WEST SUSSEX COUNTY COUNCIL CONSULTATION

TO:	Arun District Council FAO: Hebe Smith
FROM:	WSCC – Highway Authority
DATE:	24 September 2026
LOCATION:	Land West Of Ryefield Farmhouse Oak Tree Lane Woodgate PO20 3GU
SUBJECT:	AL/63/26/DOC Approval of details reserved by condition under AL/31/22/PL relating to Condition 4 - External Materials & Finishes; Condition 8 - Hard & Soft Landscaping; Condition 9 - Construction and Biodiversity Management Plan and Condition 10 - Broadband Provision. PLANTING PLANS AND CEMP received.
DATE OF SITE VISIT:	n/a (desktop study undertaken for purposes of this DOC application)
RECOMMENDATION:	More Information required

This is the **second** WSCC Highways response to the above planning application seeking approval of details reserved by condition under AL/31/22/PL relating to Condition 4 - External Materials & Finishes; Condition 8 - Hard & Soft Landscaping; Condition 9 - Construction and Biodiversity Management Plan and Condition 10 - Broadband Provision.

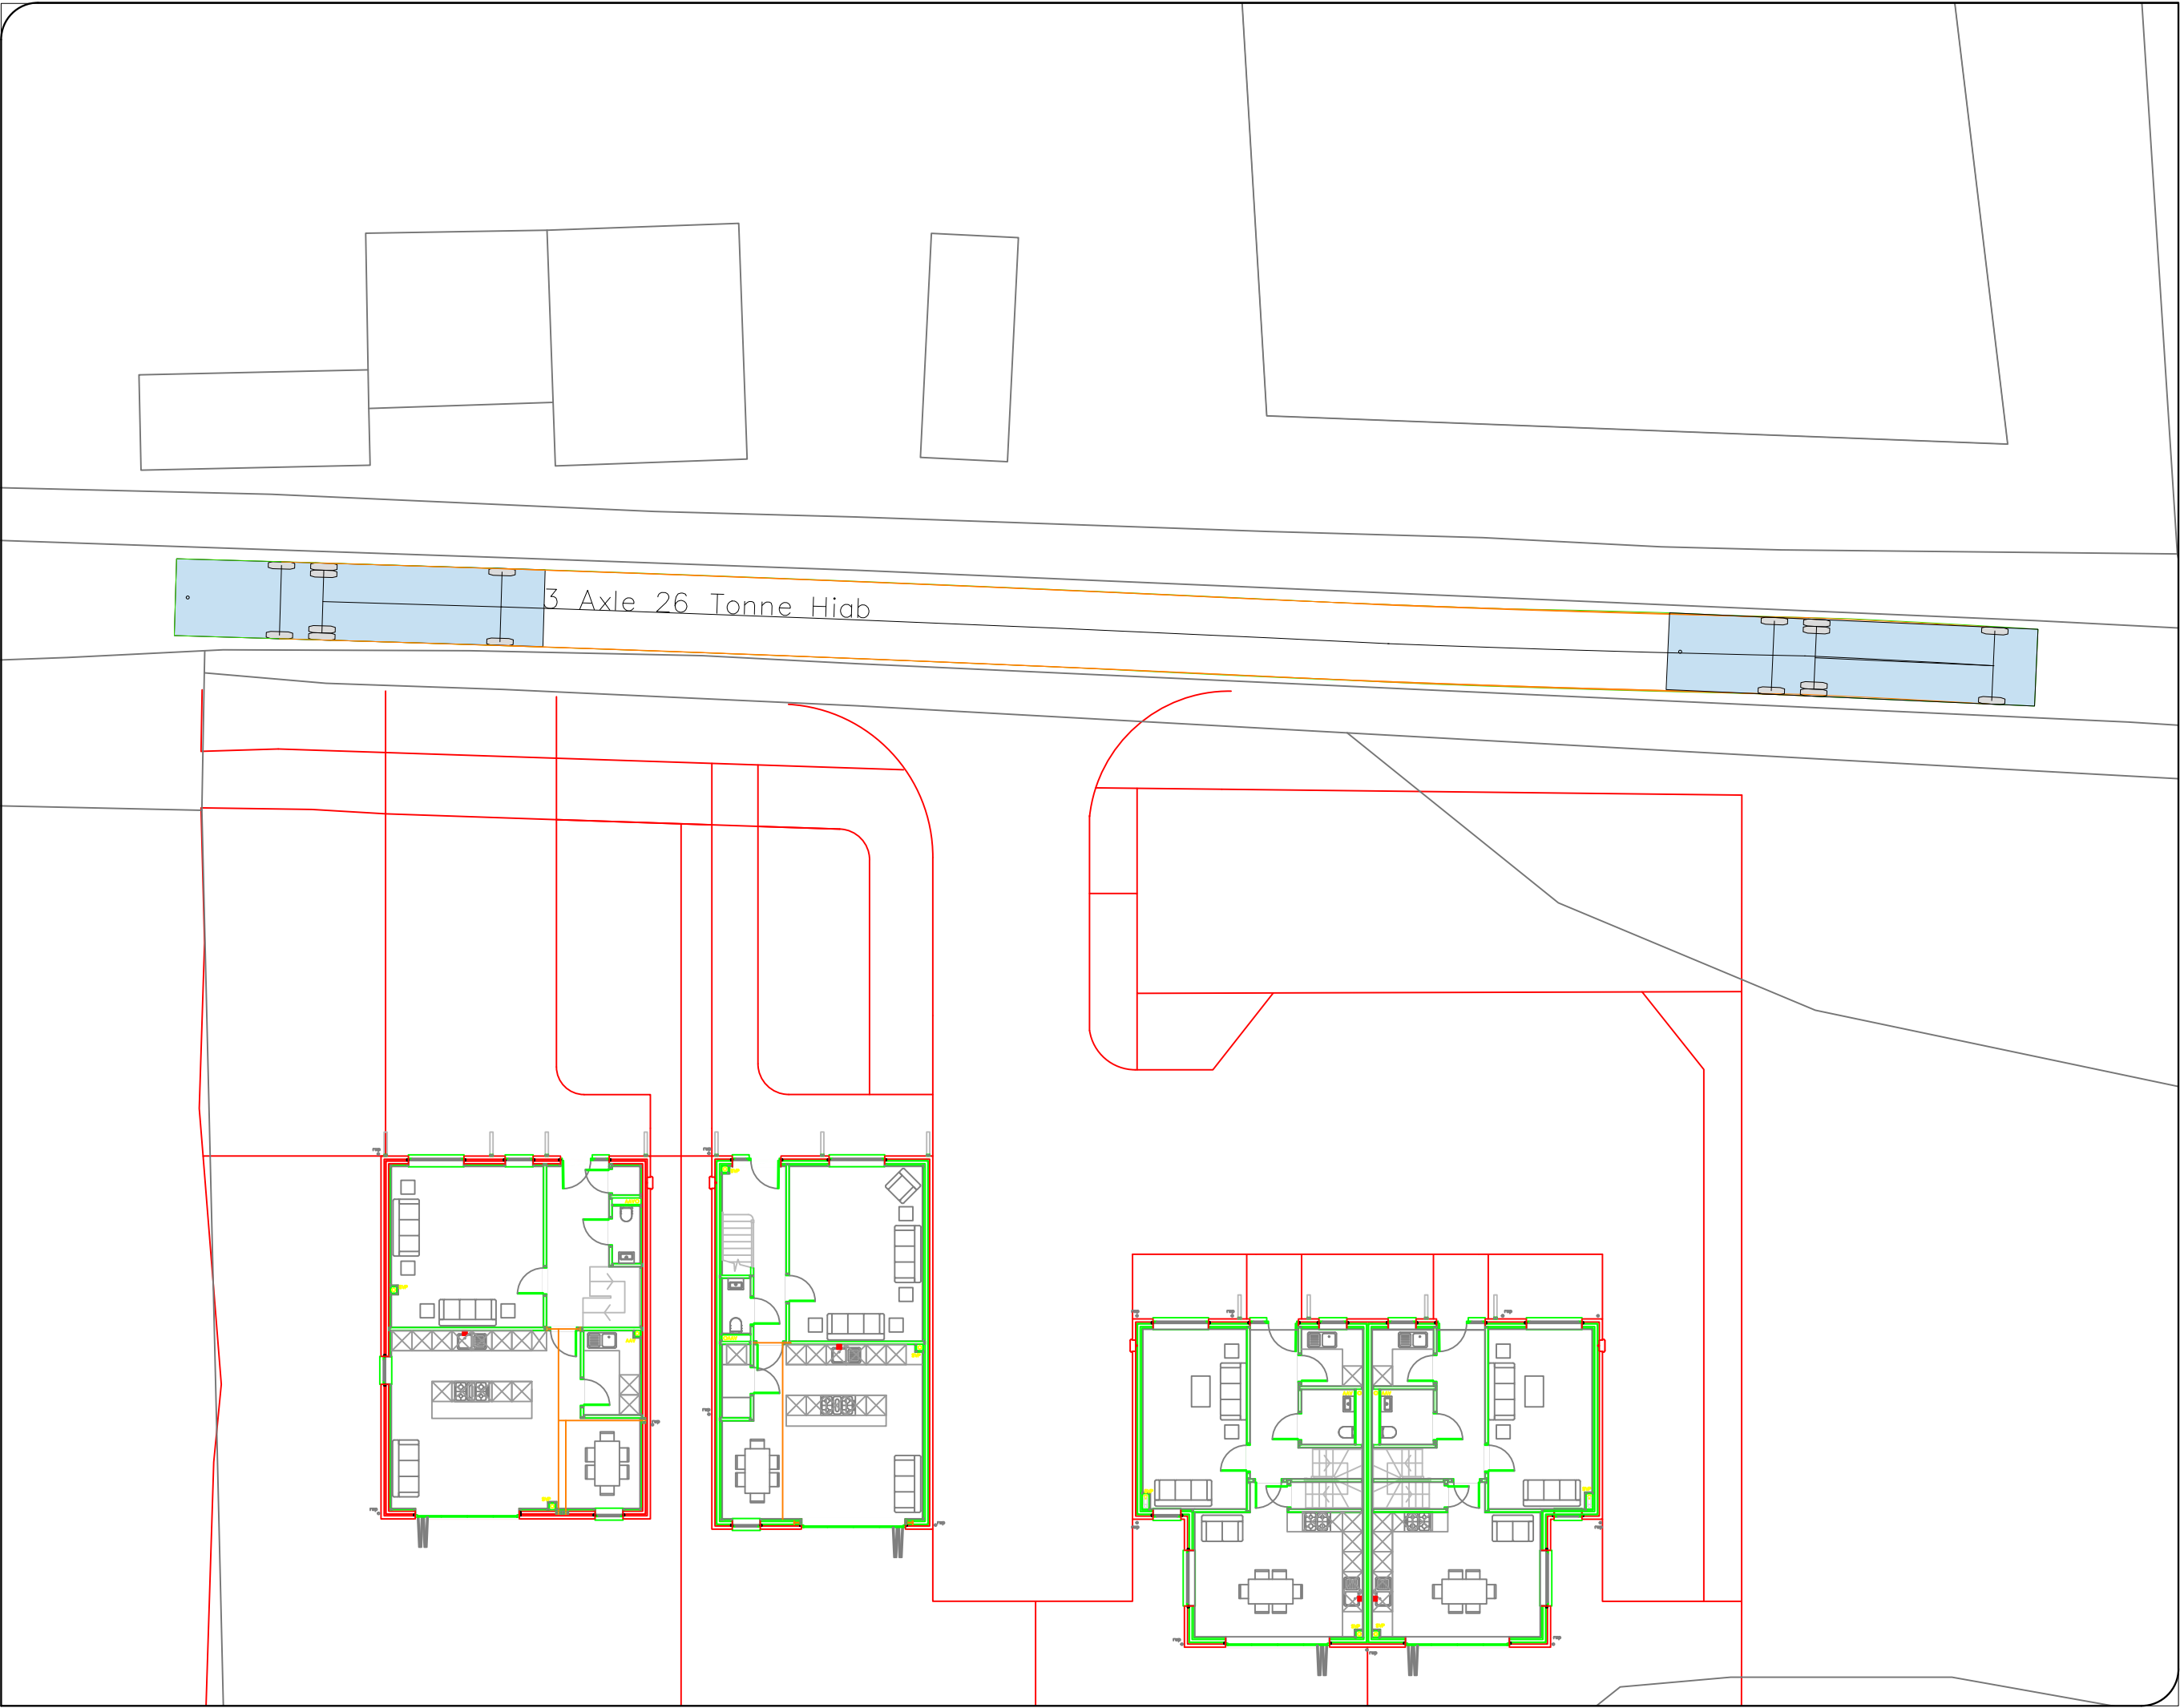
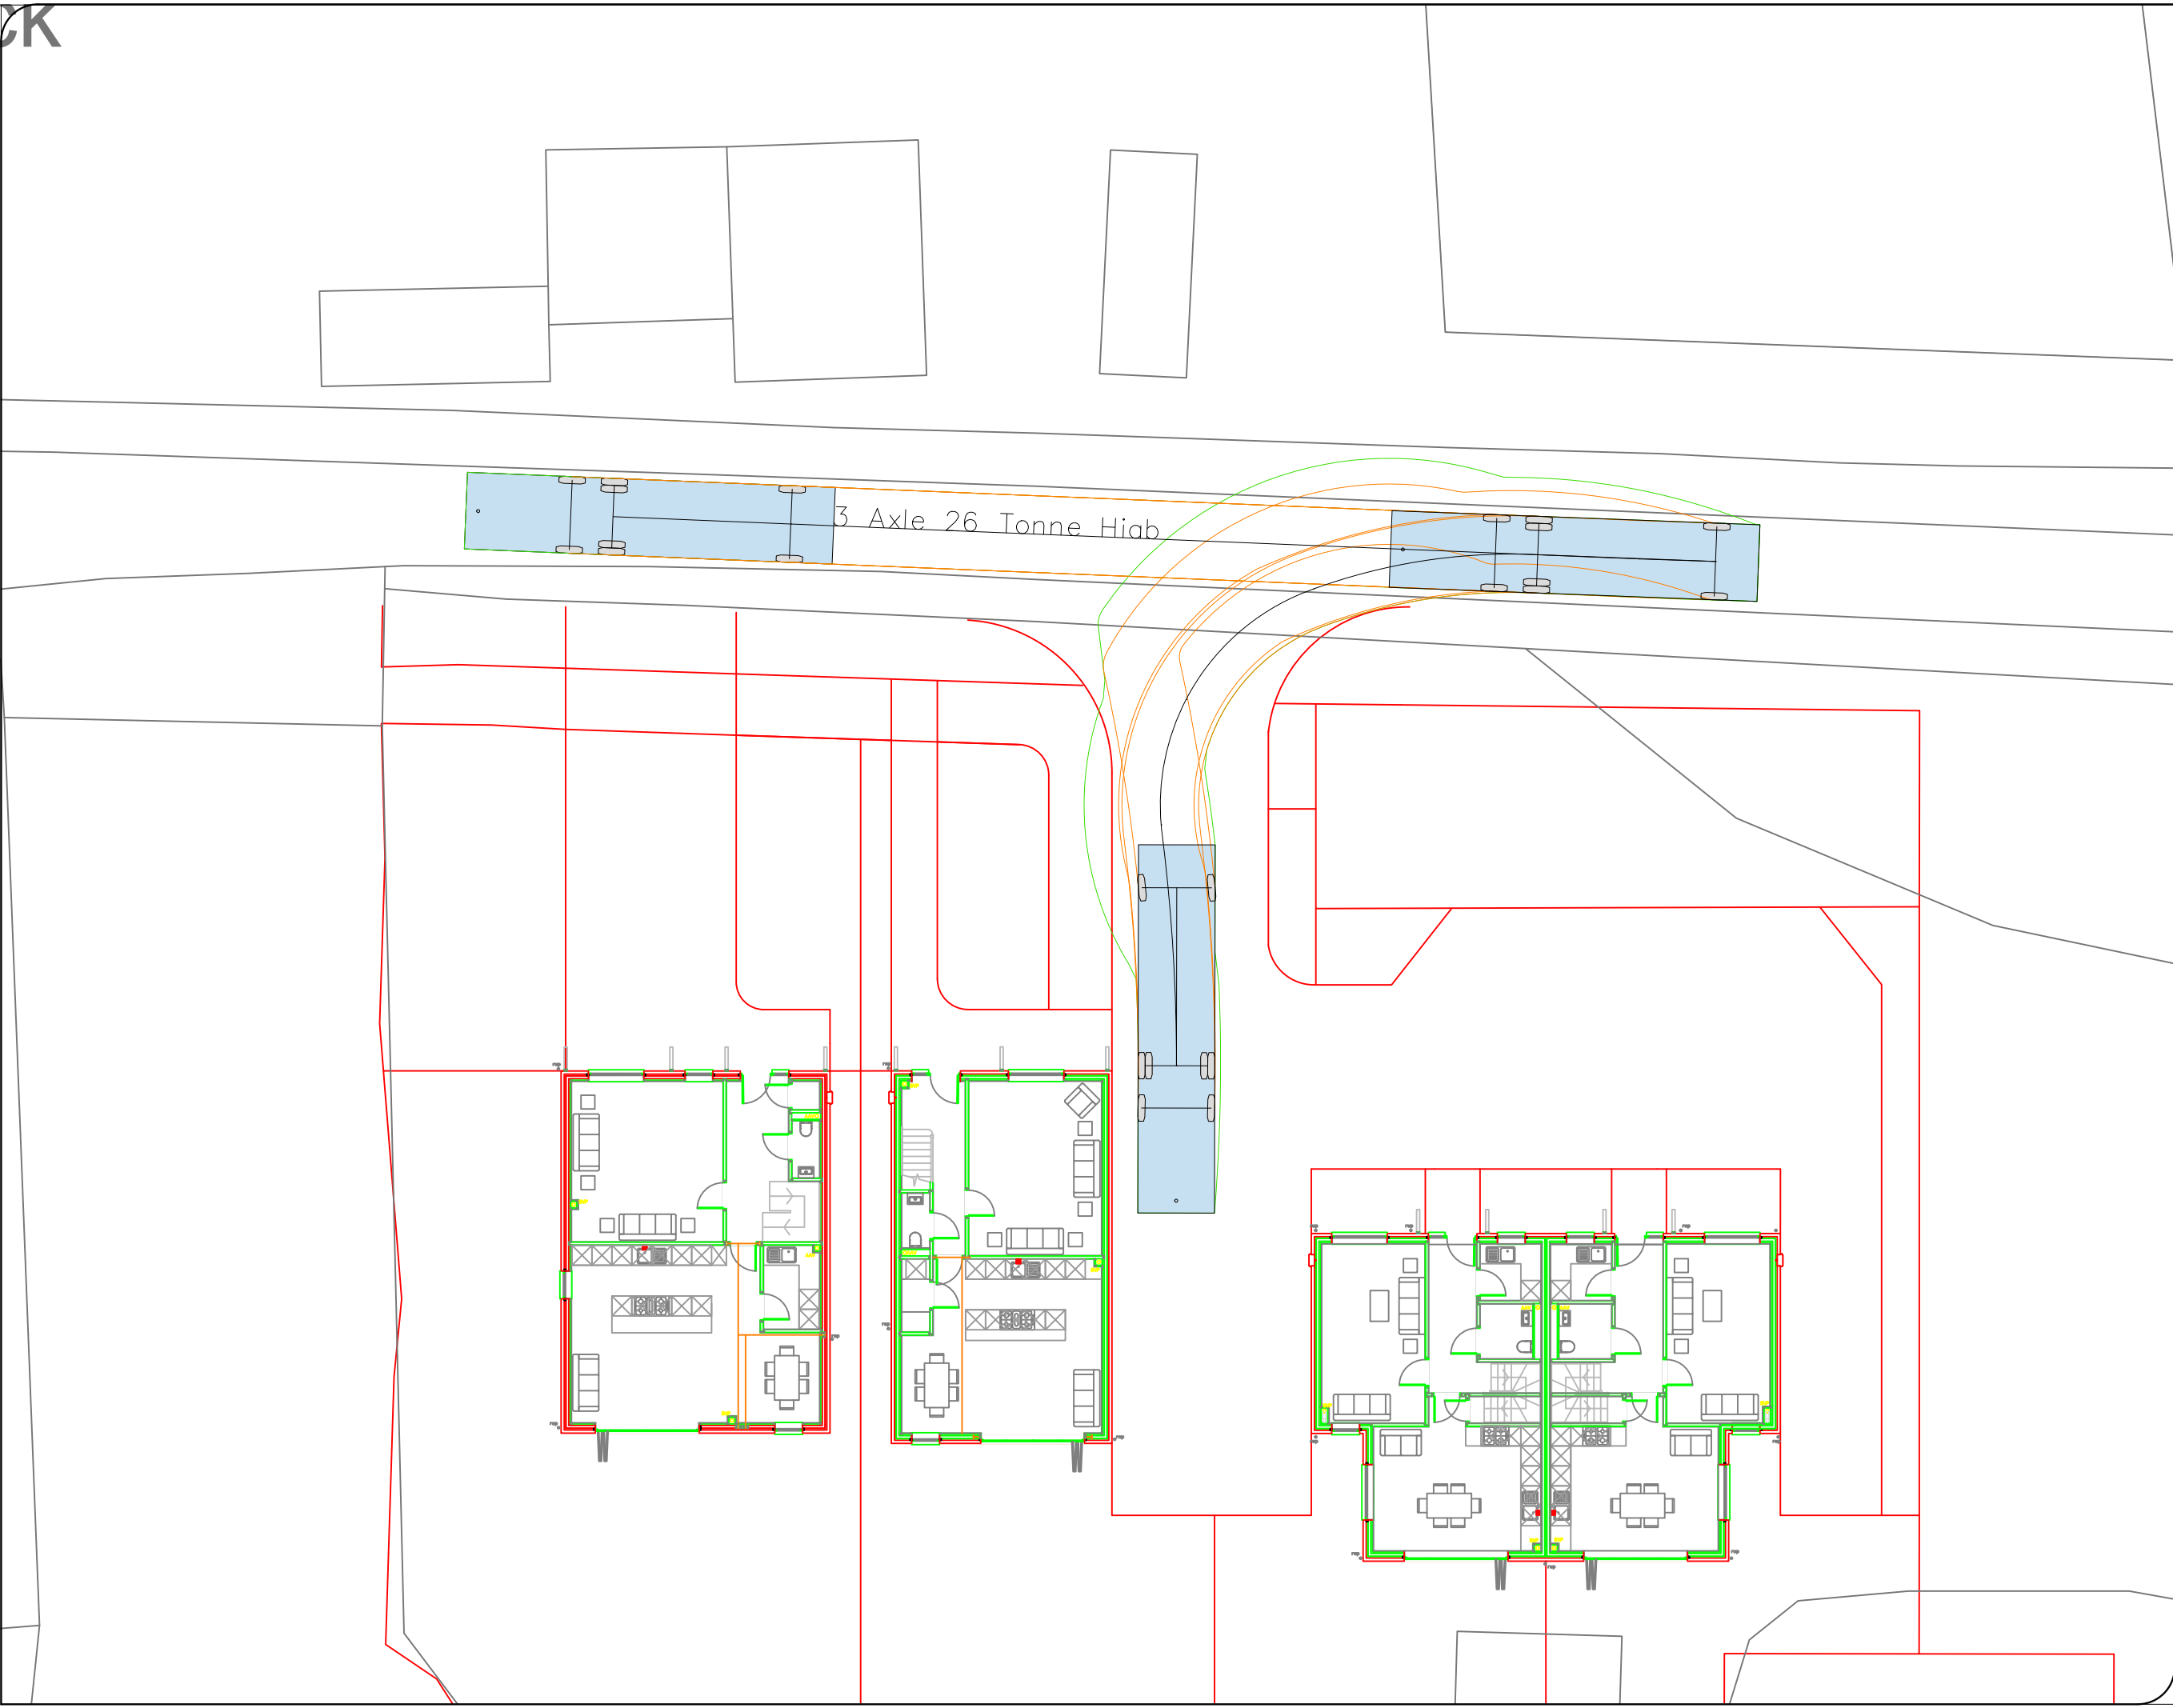
2. Condition 9 – Construction and Biodiversity Management Plan. Out of hours contact details should be included in any approved CEMP and additionally, made available to local residents and displayed on the site hoarding. *Now included on page 8 of the revised/updated CBMP.* With regard to turning of vehicles clear of the access 'road', the CEMP does not show how construction-related vehicles would be able to do this. Any final CEMP should show how all sizes of vehicles will be able to enter and exit the site (and turn within it) without having to reverse along Oak Tree Lane. *A plan is shown on page 5 of the revised/updated CBMP. However, this simply shows that a car/small van-sized vehicle could enter and leave the site in a forward gear and turn within it. No further analysis is provided for other vehicles expected to access the site during the construction phase. Paragraph 4.3.1 found on page 11 of the revised/updated CBMP makes reference to turning being available within the site for vehicles. However, the swept path analysis, recommended by the Highway Authority previously, is not shown for any vehicles larger than a car or small van. As such, the document should be further updated to include this.*
